Notes of 3/15/18 MMC Check-in Mtg- Detour issues; Schedule & Communication Plan

Key points from the **3/15/18** Site Plan Review meeting with MMC:

Boynton Street Detail

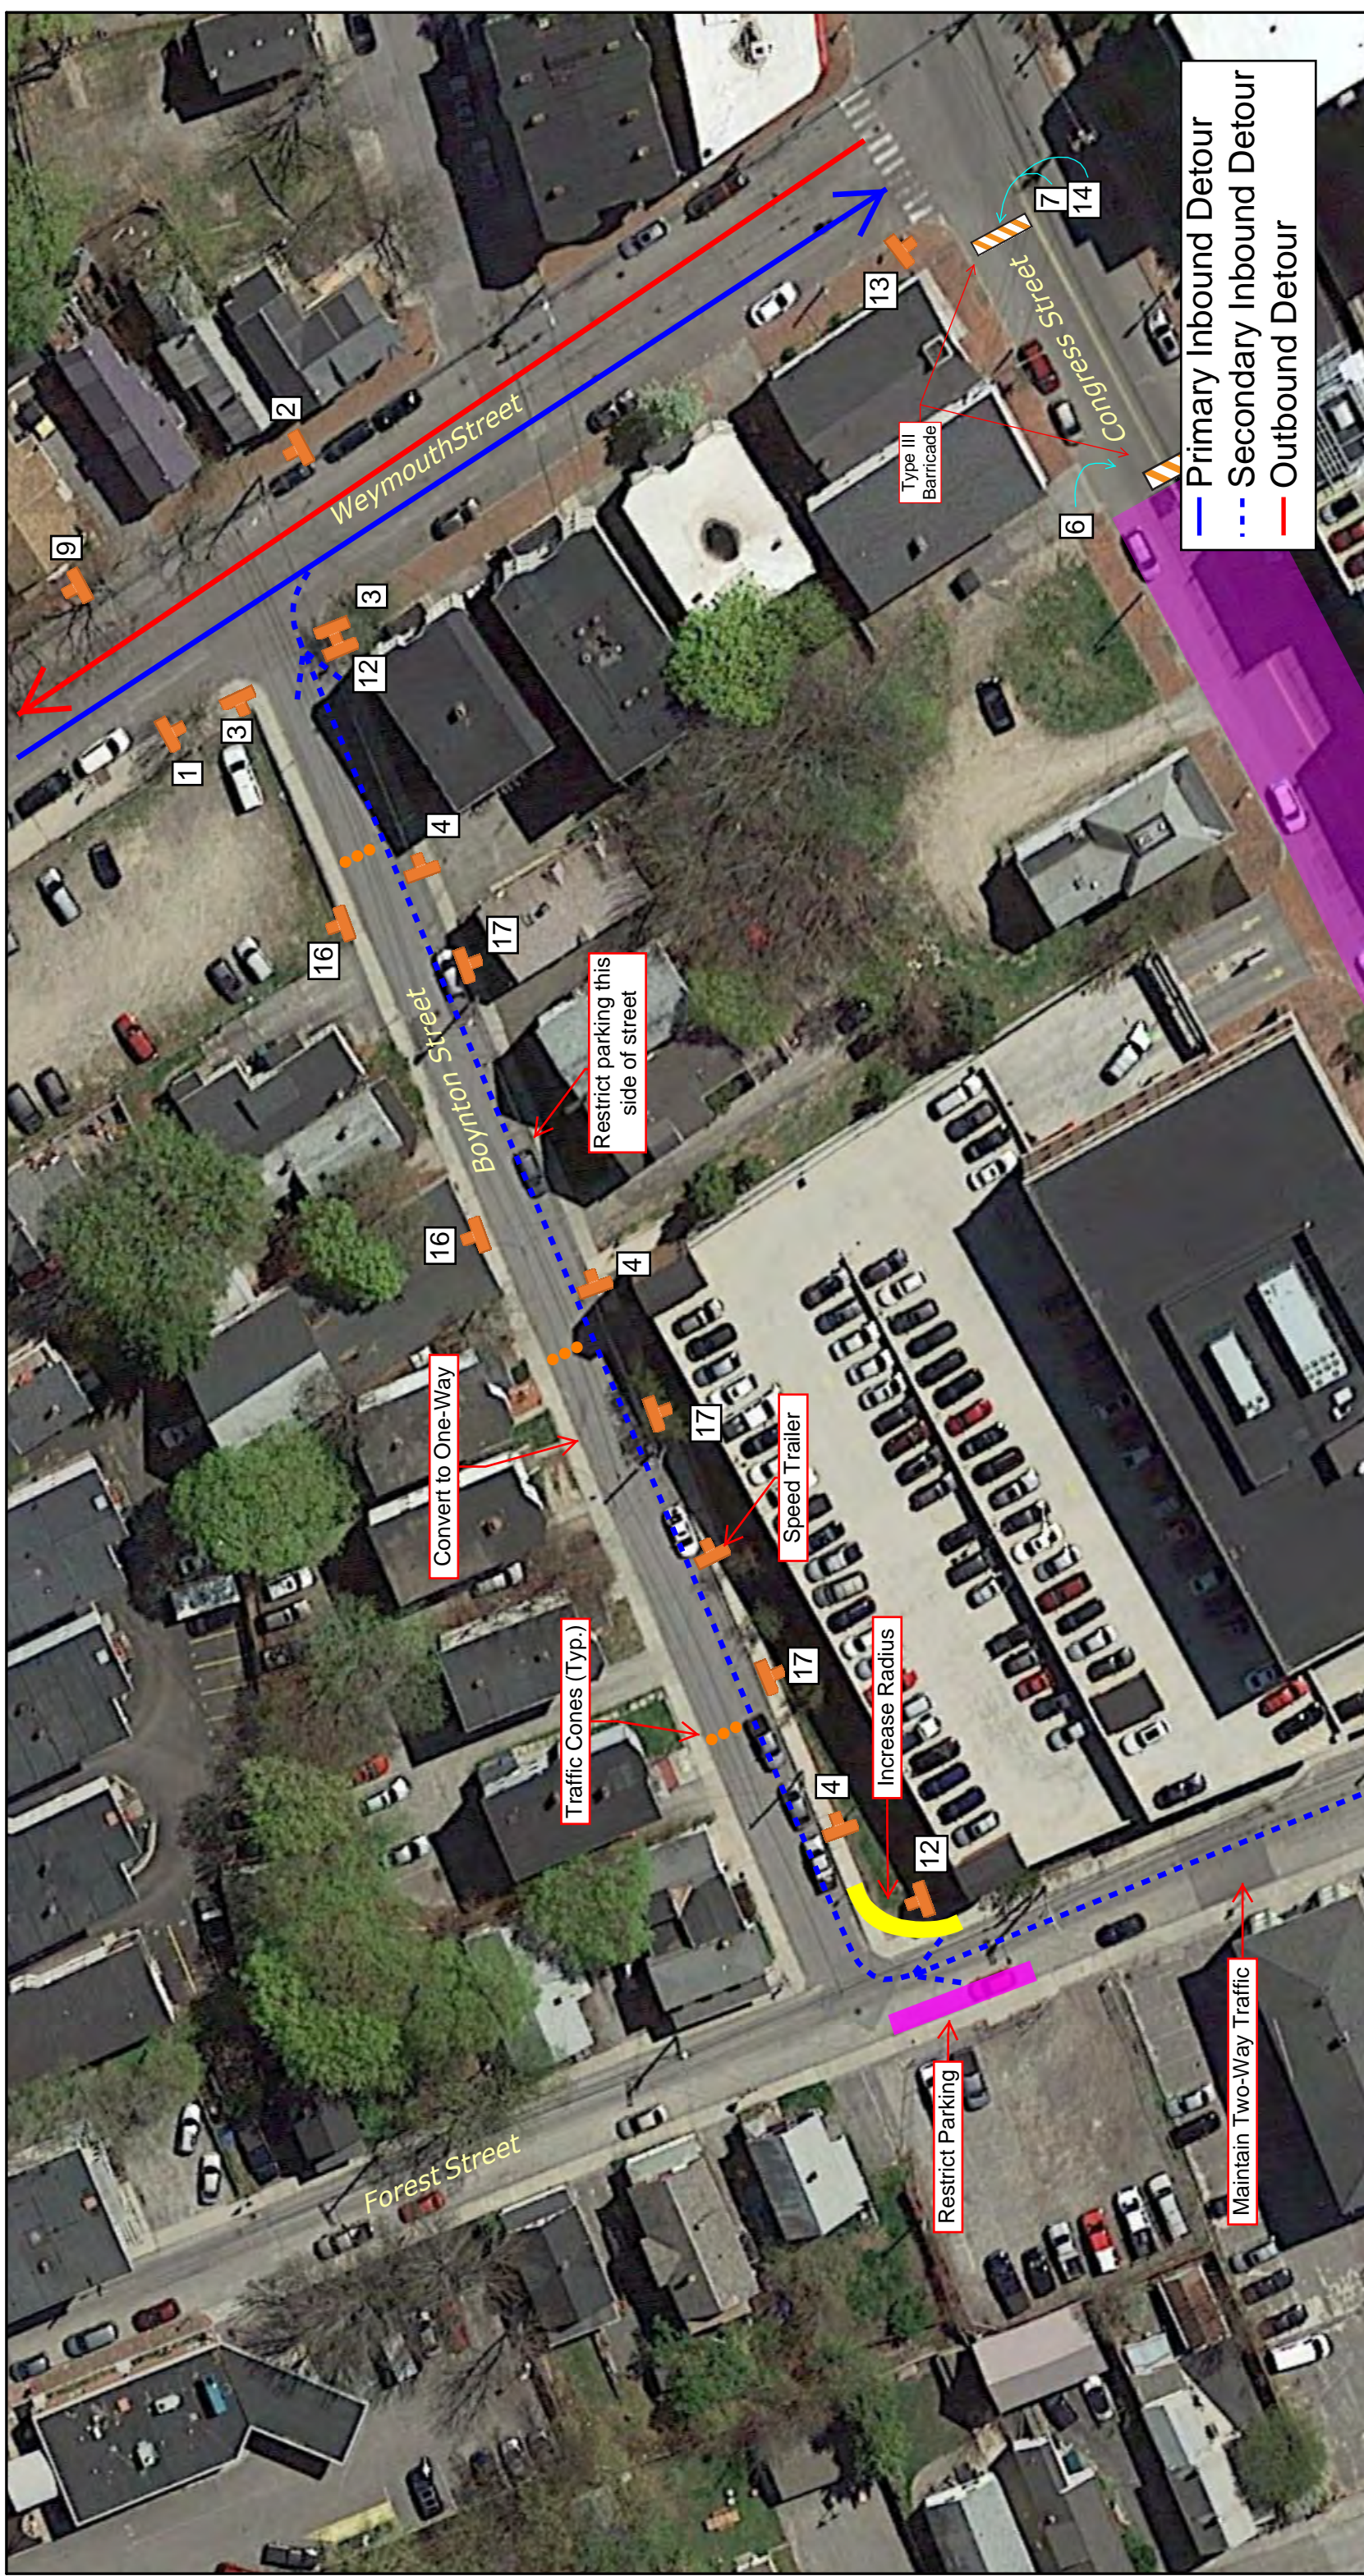
- Police noted this a concern - Park Ave westbound a potential bottleneck as no alternative route
- **RADII FOREST TO BOYNTON RIGHT TURN**
 - Regarding the turning radius at Boynton/Forest, KG and TE both were concerned and requested seeing turning template of a fire truck making the right turn into Boynton from Forest

- UPDATE: 3/16 RD of G-P had done the autoturn and MMC has concluded they need to modify that radii and it will be part of the updated MOT that will be in the PB Packet

METRO Modifications Due to Congress Street Closure

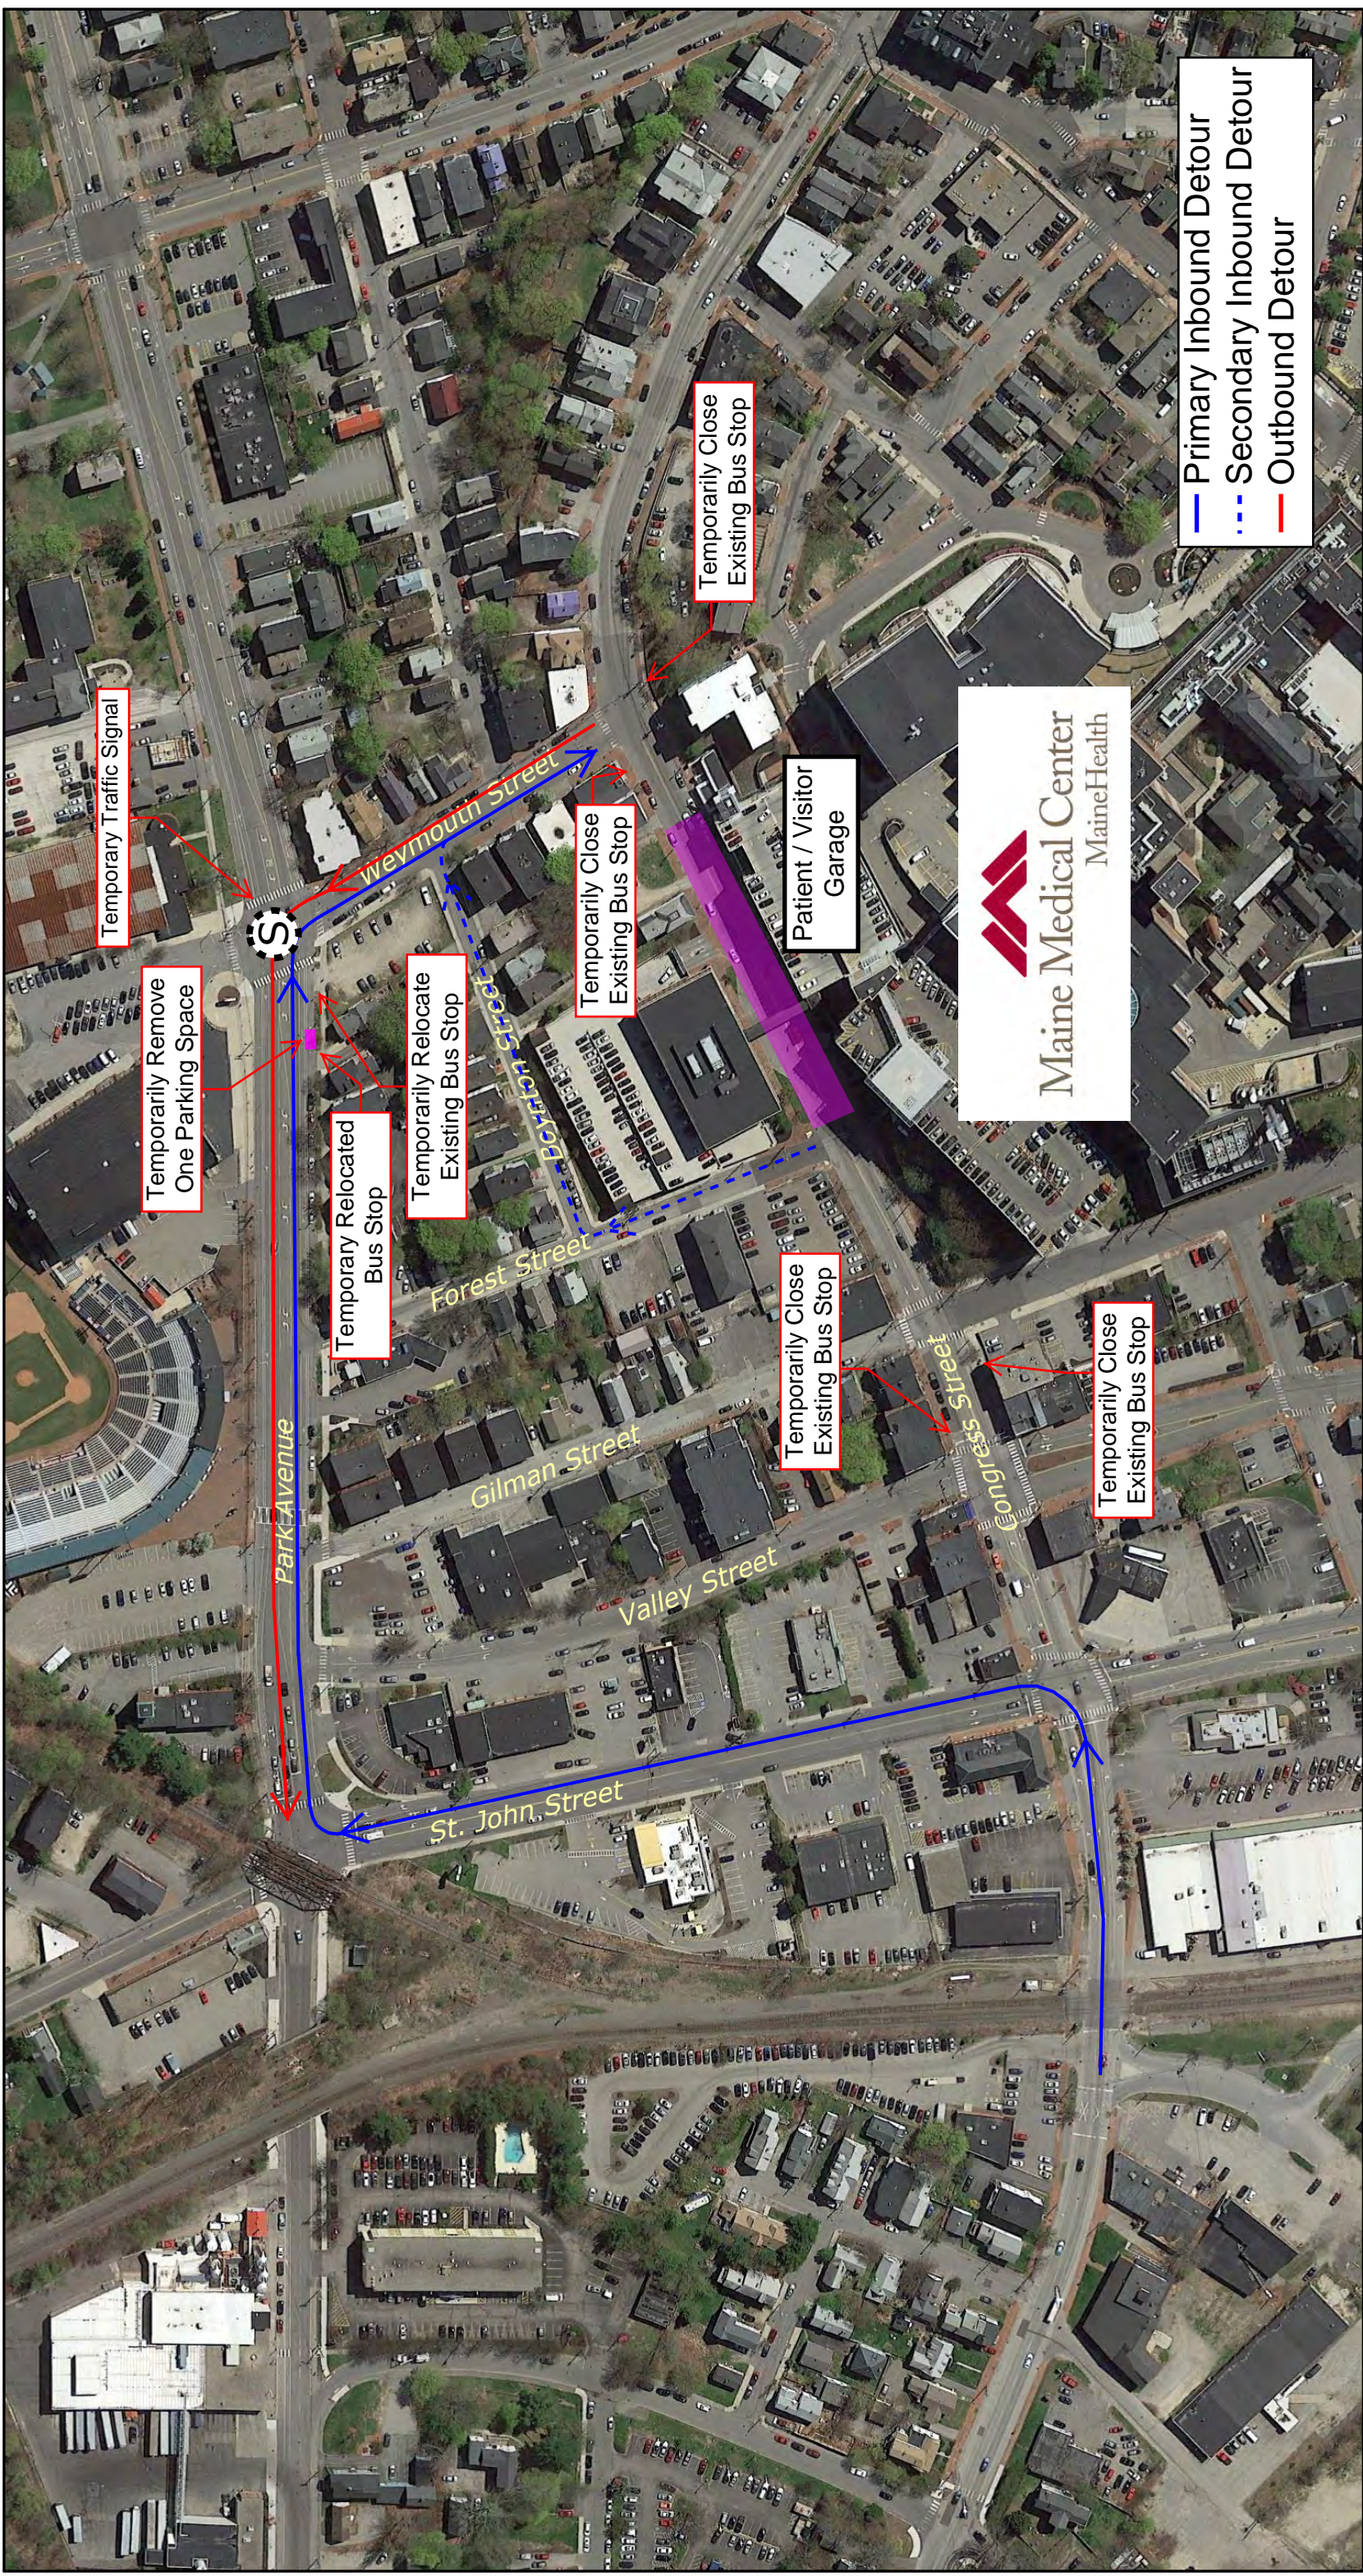
- UPDATE 3/16: Sebago has prepared details for temporary crosswalks and these will be in the MOT
- **METRO** Stop inbound on Park just before Weymouth Street

- Metro had requested that the stop be relocated about 40 feet west and have a concrete slab created between the curb and sidewalk for bus passengers
 - Note that parking spaces would need to be removed but DPW have authority to close 2 parking spaces

- Question as to whether METRO would want the stop and pad to remain permanently - if not, is it worth pouring the pad? BH to check with METRO
- **SIGNAL AT WEYMOUTH/PARK**

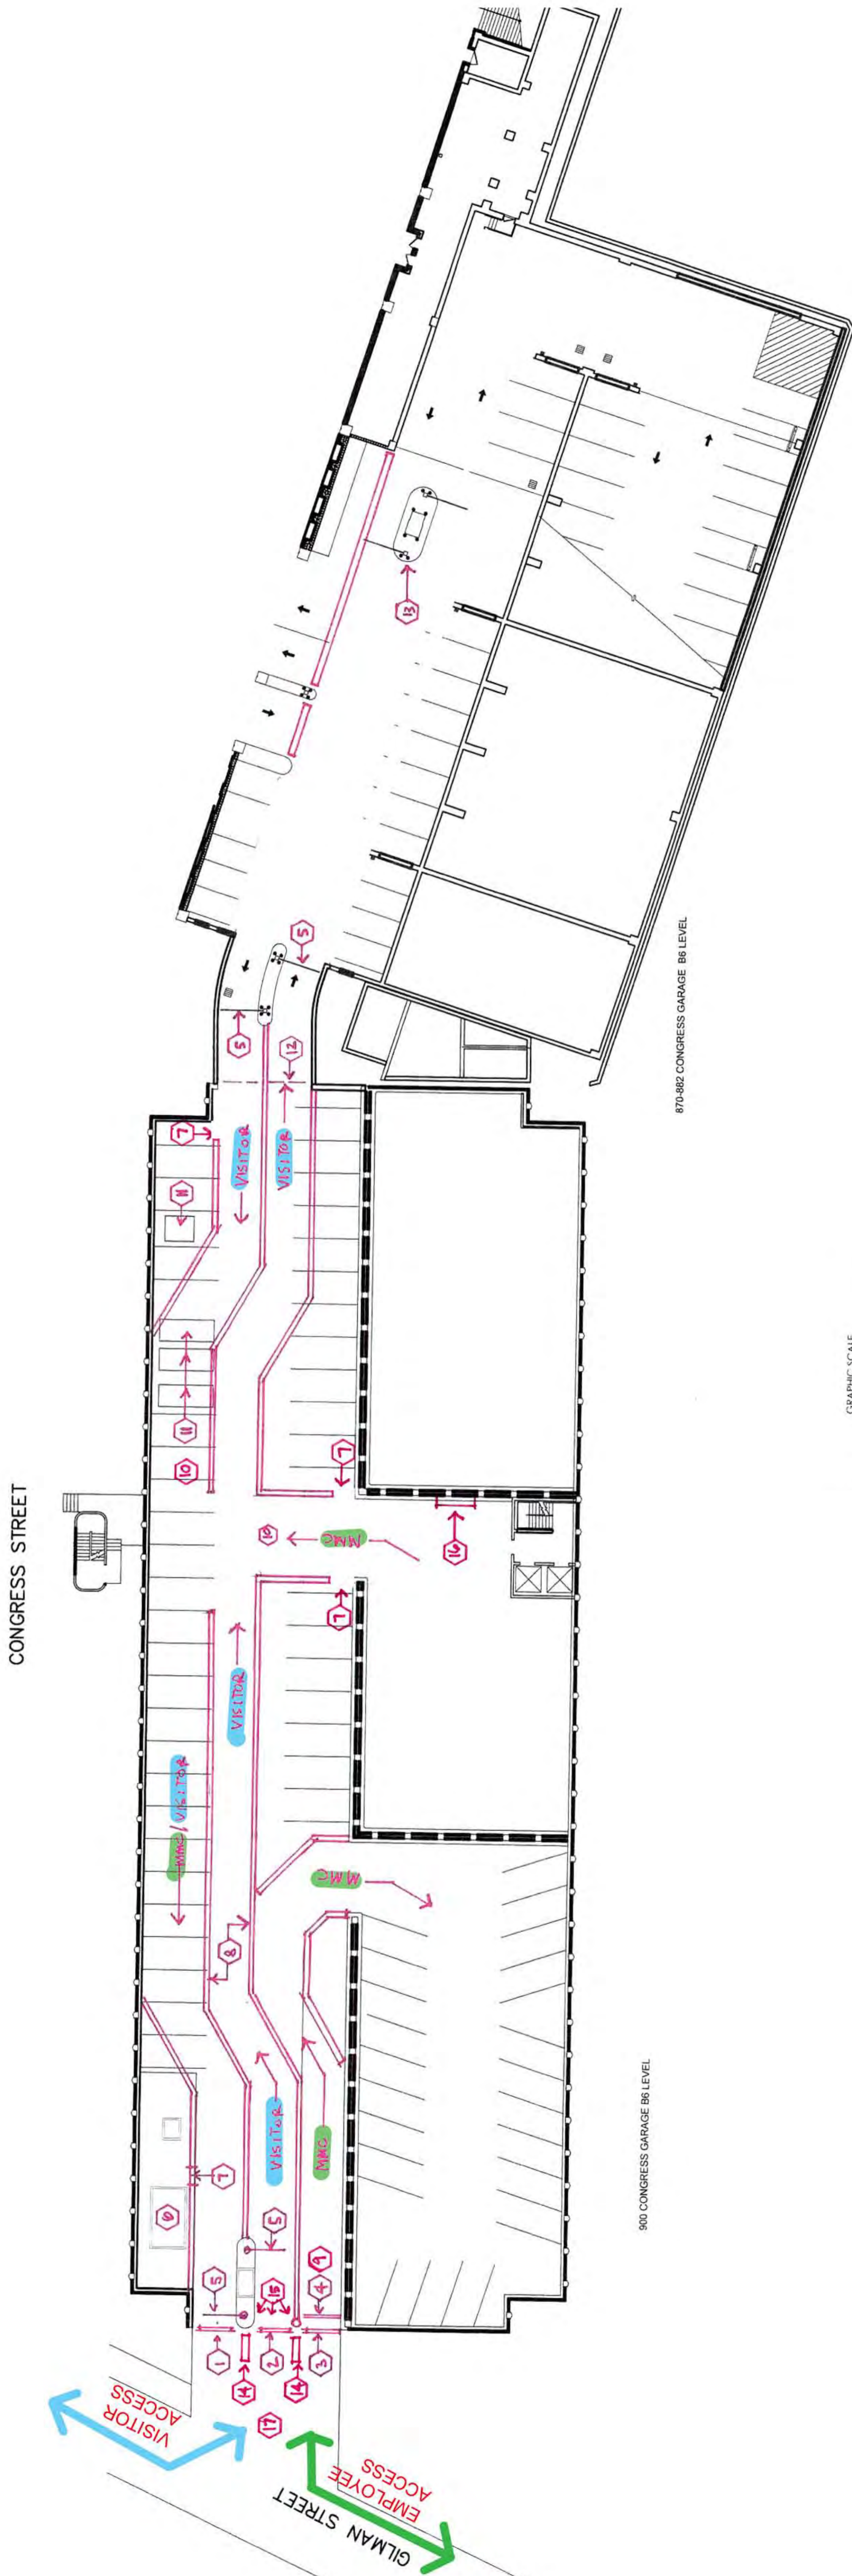
- Short section of outbound lane to be left open in front of MOB for access for ambulances etc
 - Police concerned re night issues here
- **SIGNAGE**
 - Signage Plan in MOT needs some updating - but is detailed enough for now

- City staff will review the spray-painted sign locations
- Variable message signs being discussed with MDOT
- **COORDINATION WITH MDOT** (see last item in the attachment)
 - All has been agreed; MMC will provide the variable message boards
